| <b>Application Ref:</b>            | 3/2026/0239 |                     |     | <br>Ribble Valley<br>Borough Council<br><a href="http://www.ribblevalley.gov.uk">www.ribblevalley.gov.uk</a> |                 |  |  |  |
| <b>DELEGATED ITEM FILE REPORT:</b> |             |                     |     |  | <b>APPROVAL</b> |  |  |  |

| <b>Development Description:</b> | Certificate of Lawfulness for proposed hip to gable and rear dormer extension. |
| <b>Site Address/Location:</b>   | 23 Hawthorne Place Clitheroe BB7 2HU   |

Drawing Title
PROPOSED ELEVATIONS

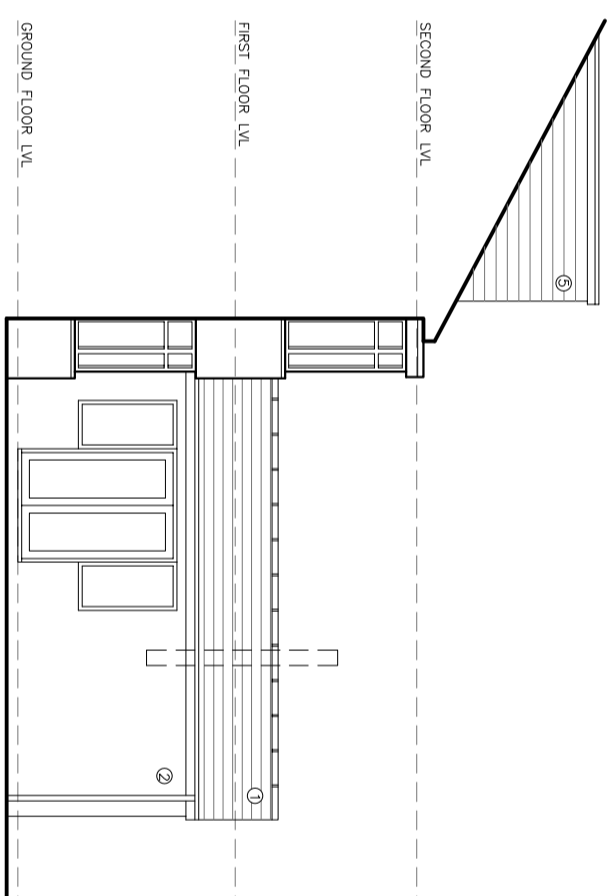
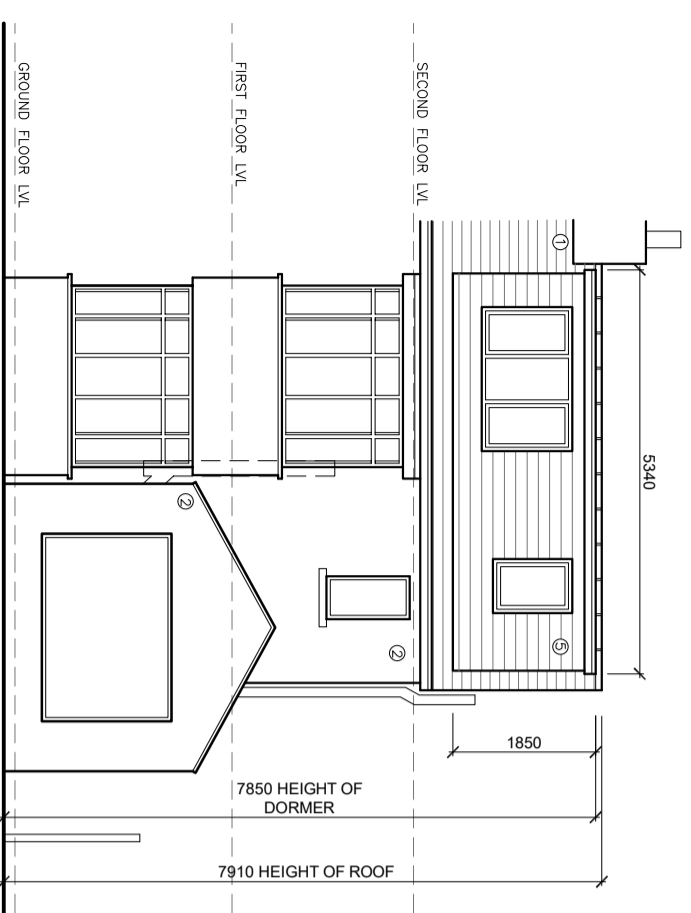
| Consent is sought for a Certificate of Lawfulness for the construction of a proposed hip to gable and rear dormer extension, with two subsequent windows to the dormer's rear elevation. The proposed dormer would project out 3.6 m from the rear roof slope of the dwelling house, with a length of 5.34m and a height of 1.85m, resulting in a ridge height of 7.85m.  |

**The proposed development would not exceed the height of the existing roof.**

**No part of the proposed development would extend beyond the plane of any existing roof slope which forms the principal elevation and fronts a highway.**

**The site is a semi-detached dwelling, and the cubic content of the resulting roof space would exceed the cubic content of the original roof space by 27.5 cubic metres.**

**The eaves of the original roof would be maintained or reinstated, and the edge of the proposed dormer would be more than 0.2m from the eaves. The proposed development would also not extend beyond the outside face of any external wall of the original dwellinghouse.**

**No window would be inserted on a wall or roof slope forming a side elevation of the dwelling house.**
